KIRKLEES METROPOLITAN COUNCIL INVESTMENT & REGENERATION SERVICE

DELEGATED DECISION TO DETERMINE APPLICATIONS FOR LISTED BUILDING CONSENT

Reference No:	2024/44/91707/W
Site Address:	21-23, 25 and 27 Round Ings Road, Outlane, Huddersfield, HD3 3FQ
Description:	Discharge of details reserved by condition 4 (external masonry), 8 (bi-fold doors) on permission 2024/90116 for Listed Building Consent alterations and renovations to existing dwellings 21/23, 25 and 27; erection of single storey extensions to existing dwellings 25 and 27; partial dismantling and re-building of detached barn; conversion and extension of detached and attached barns to form one dwelling; widening/improvements to existing access road, formation of parking and turning areas, together with hard and soft landscaping
Recommending Officer:	Katie Chew

Proposal Description: Discharge of details reserved by Condition 4. (external masonry) & 8. (bi-fold doors) of permission no. 2024/90116 for Listed Building Consent alterations and renovations to existing dwellings 21/23, 25 and 27; erection of single storey extensions to existing dwellings 25 and 27; partial dismantling and re-building of detached barn; conversion and

title General Arrangement as Proposed
number 23038D-02-P06
scale 1:100 or as shown
size A1

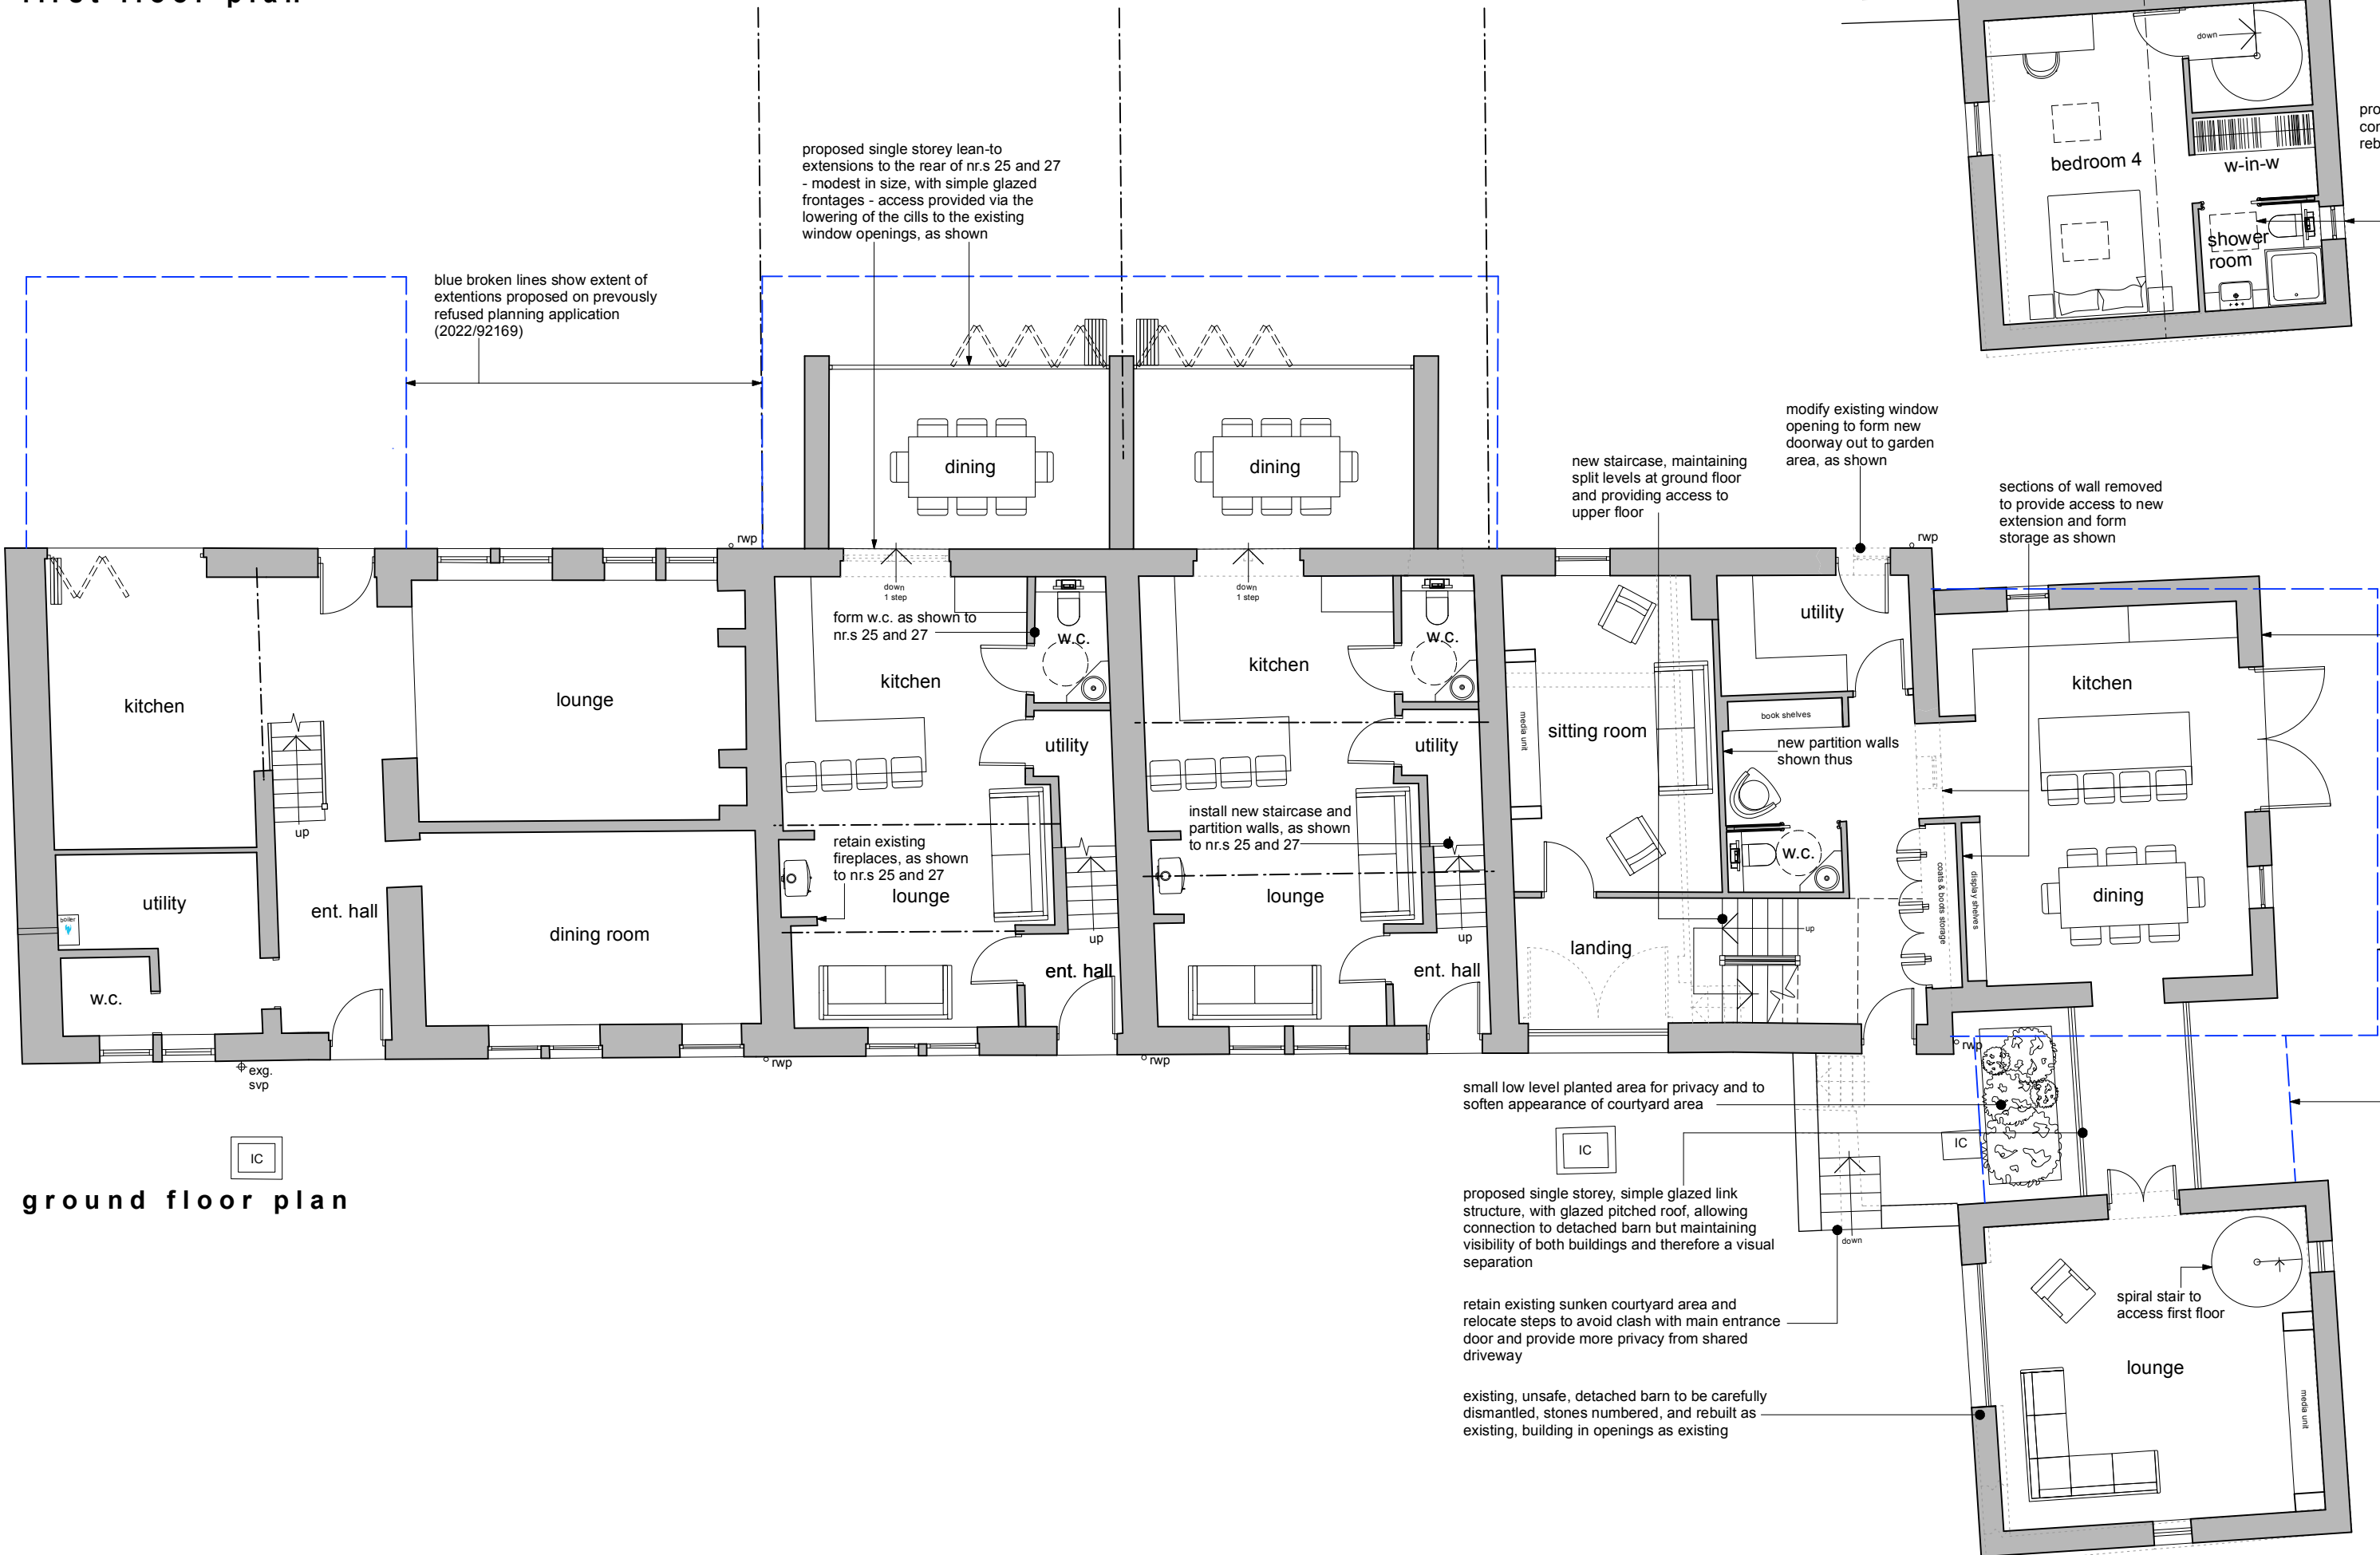
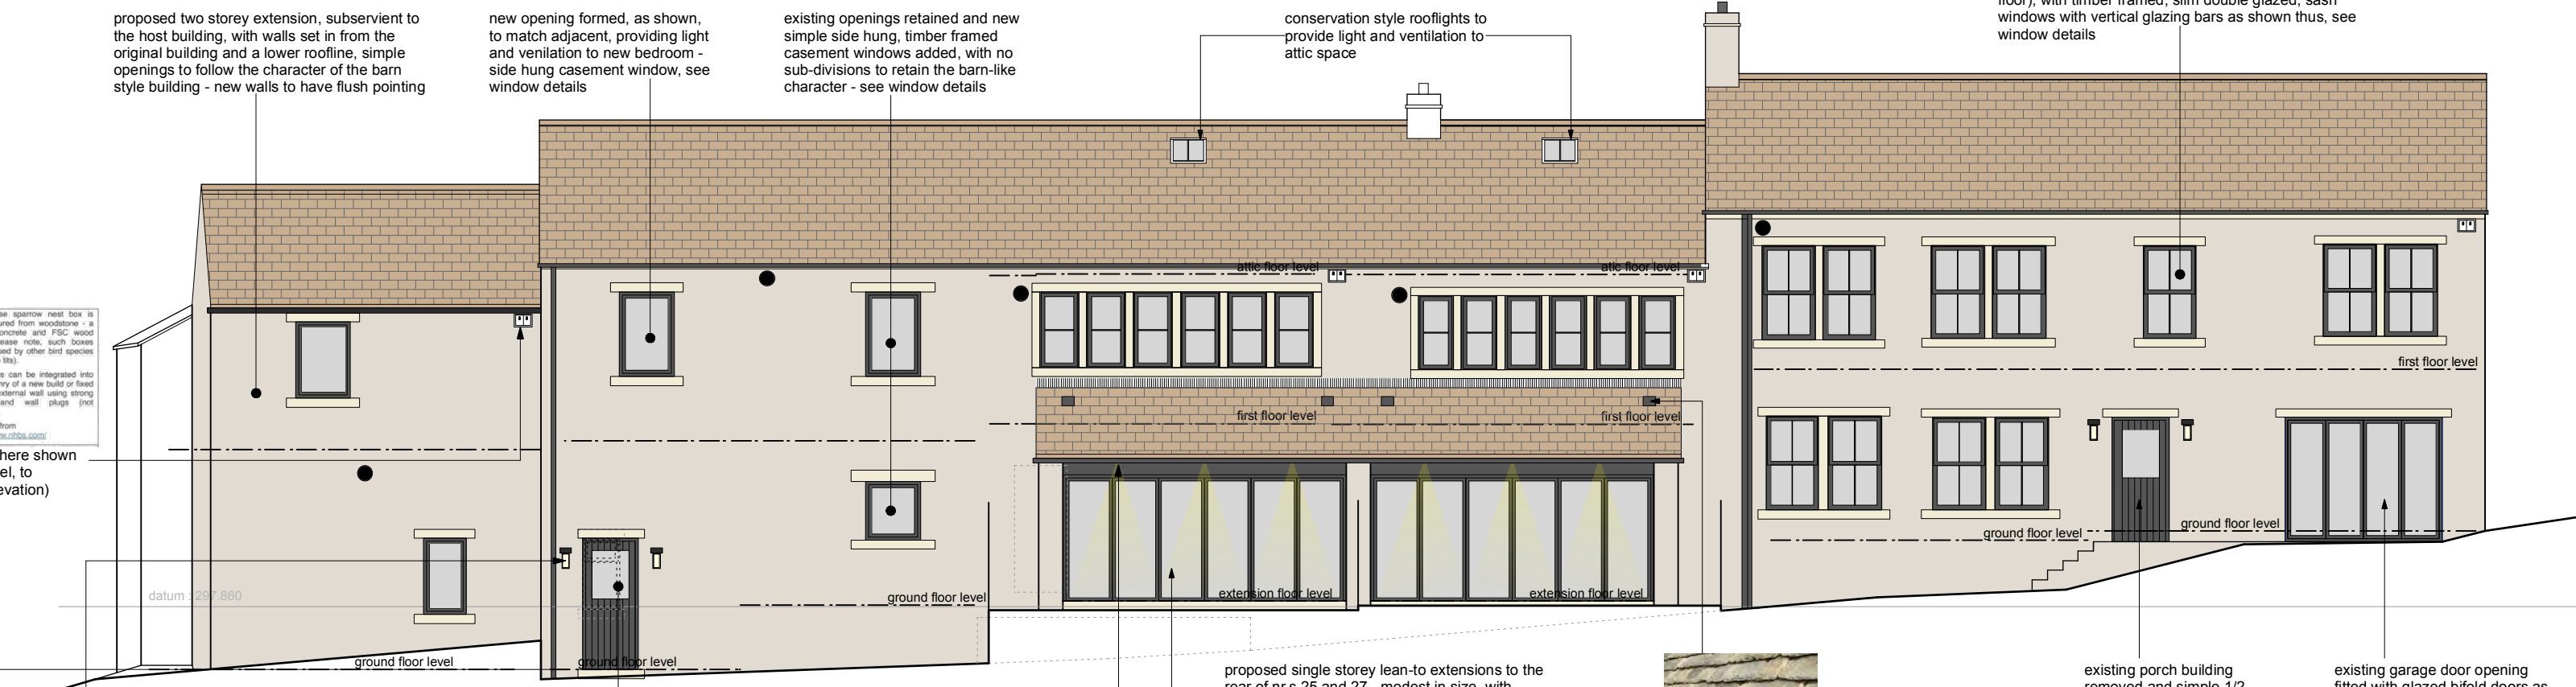
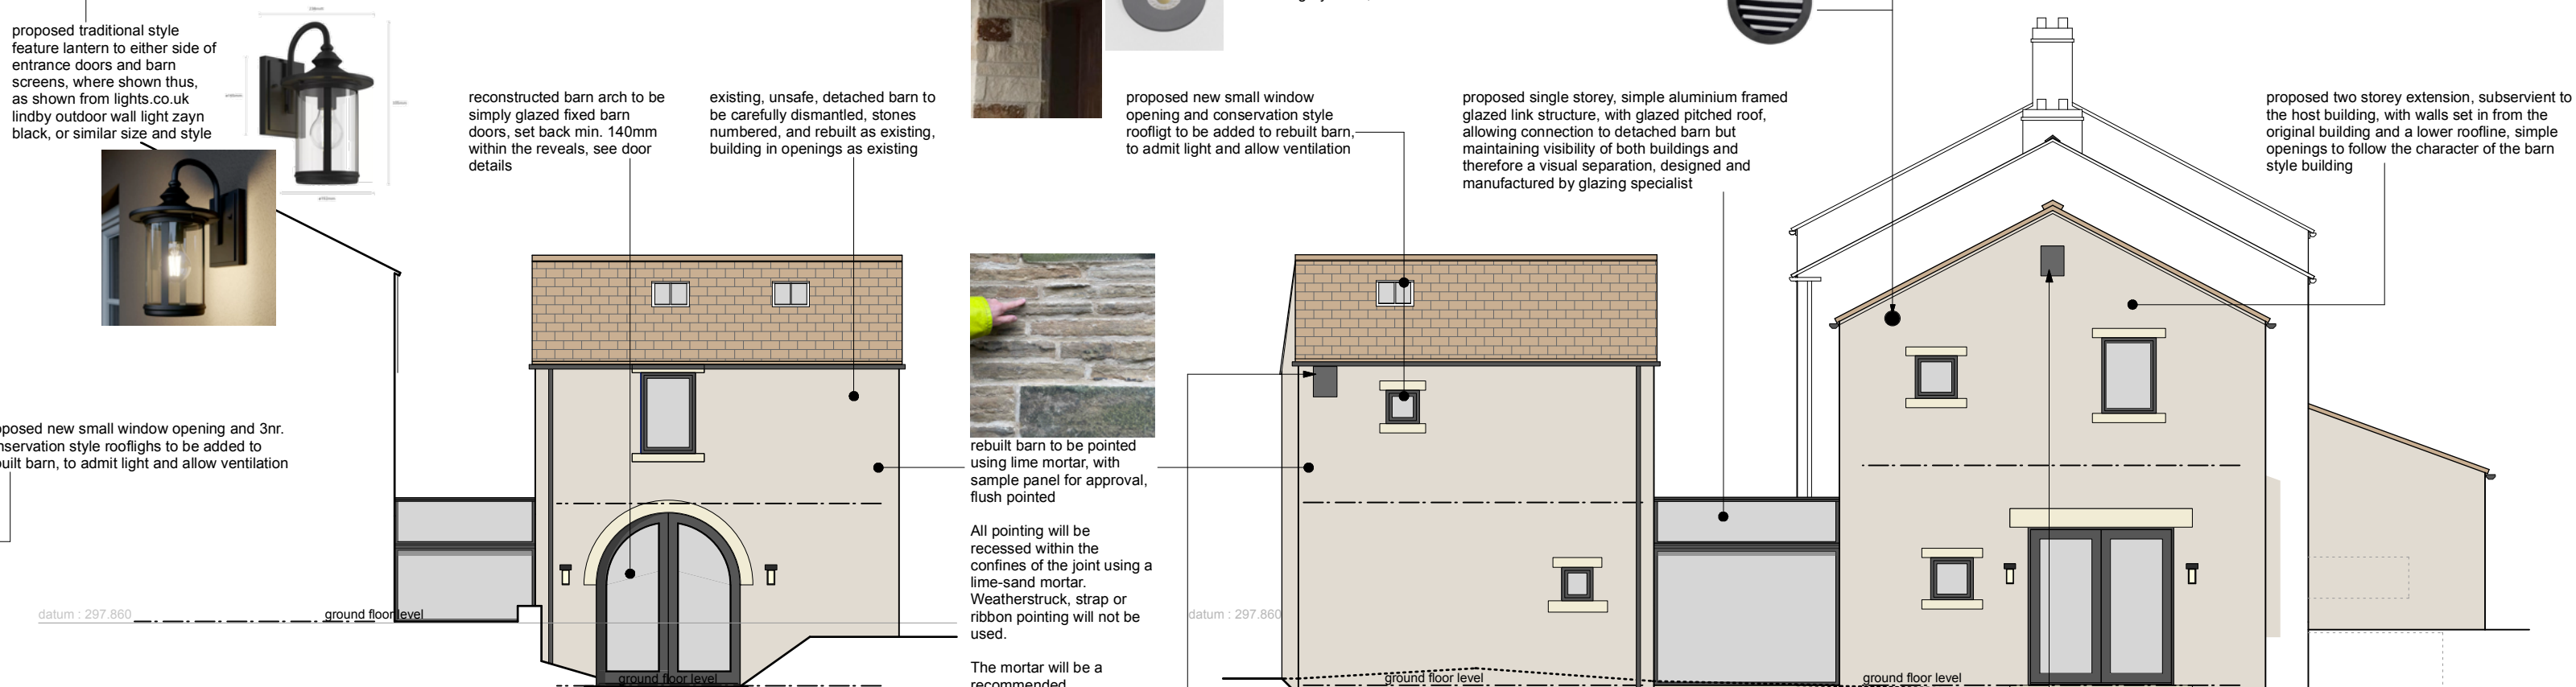
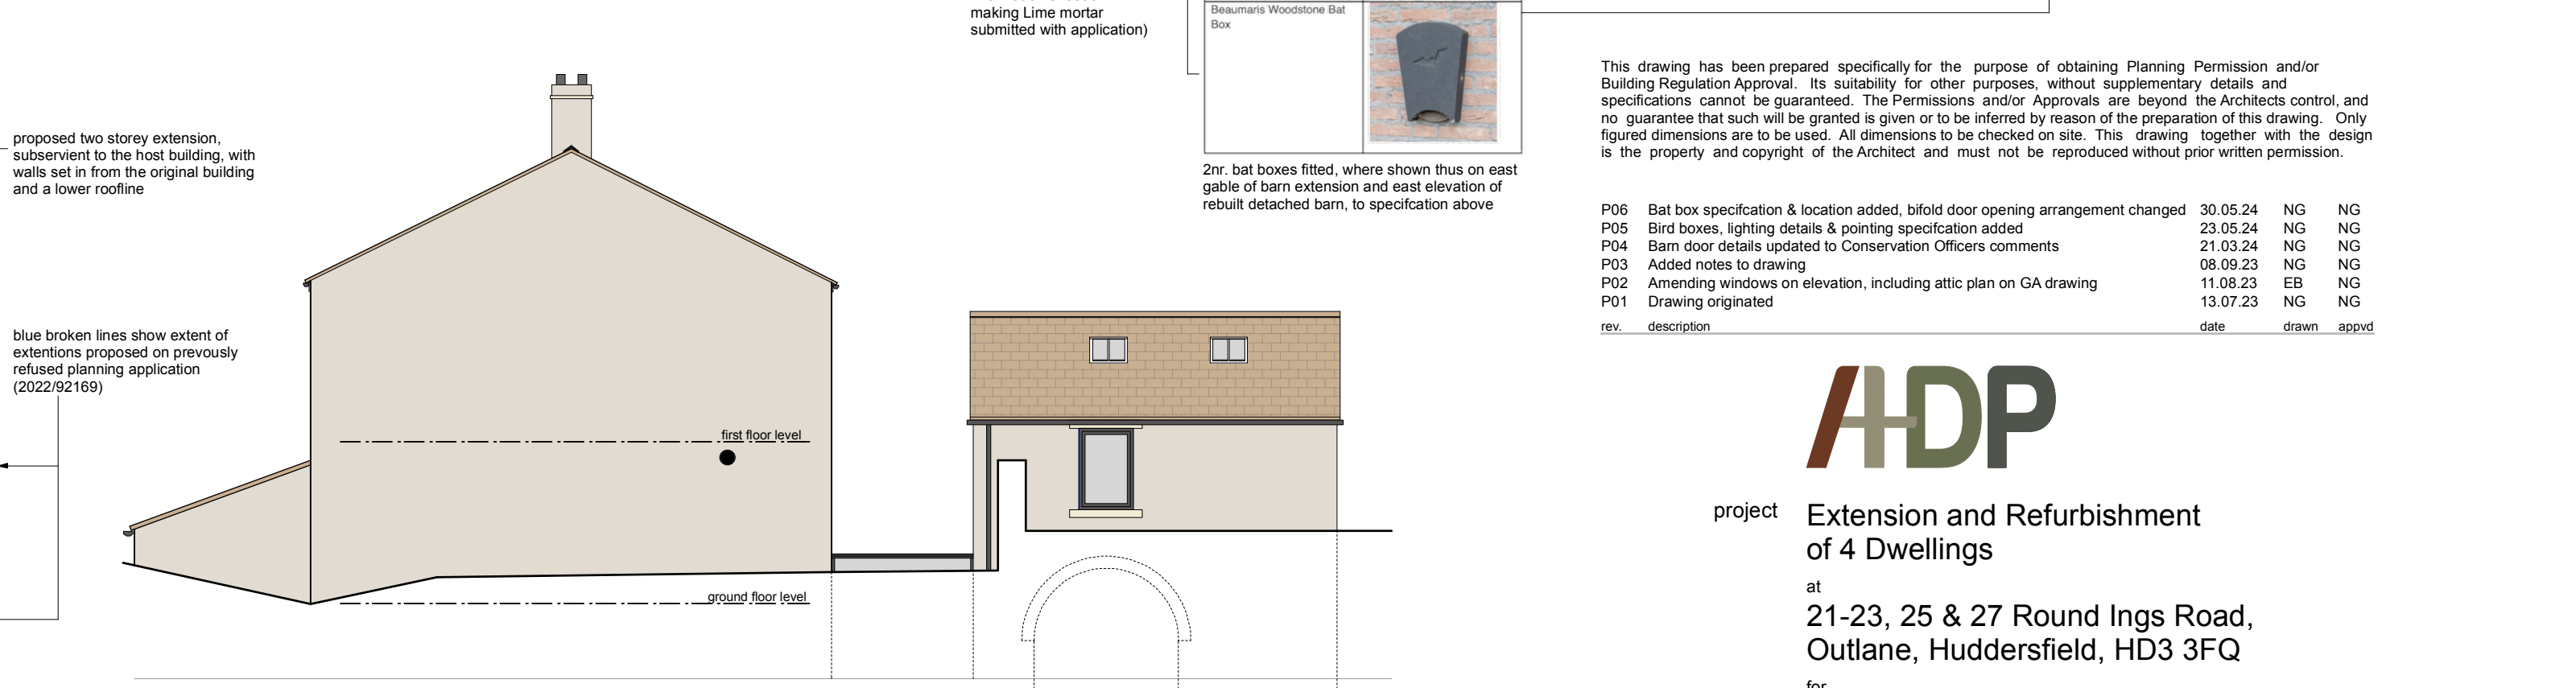
The applicant has submitted sample panel photographs submitted on the 17th June 2024 and drawing no. 23038D-02-P06 'General Arrangement as Proposed', received 17th June 2024.

Conservation & Design Officers were consulted on the proposals and noted that the sample panel shows a fine aggregate and trowelled finish rather than tamped as required, and a mixing method has been submitted rather than the mix and specification. A mortar mix and sand/aggregate specification is required, along with a revised sample panel showing a coarser aggregate and tamped finish, to enable this condition to be discharged.

Following receipt of the above comments, the applicant's agent sought to submit sample panel photographs submitted on 8th August 2024, revised drawing no. 23038D-02-P06 'General Arrangement as Proposed' which includes the mix and specification, and a Lime Mortar Mix Specification sheet.

These documents outline that all pointing will be recessed within the confines of the joint using a lime-sand mortar. Weatherstruck, strap or ribbon pointing will not be used. The mortar will be a recommended conservation mix of 1-part ionic white lime NHL 3.5 : 1.5 parts Leighton Buzzard sand: 1.5 part Nosterfield sand.

The Council's Conservation & Design team note that the amended details are deemed to be acceptable to discharge this condition. Officers concur with this conclusion and therefore Condition 4 can be discharged. It is noted however, that this condition must remain in perpetuity until the works are carried out in accordance with the approved mortar mix and sample panel, and once completed shall be retained thereafter.
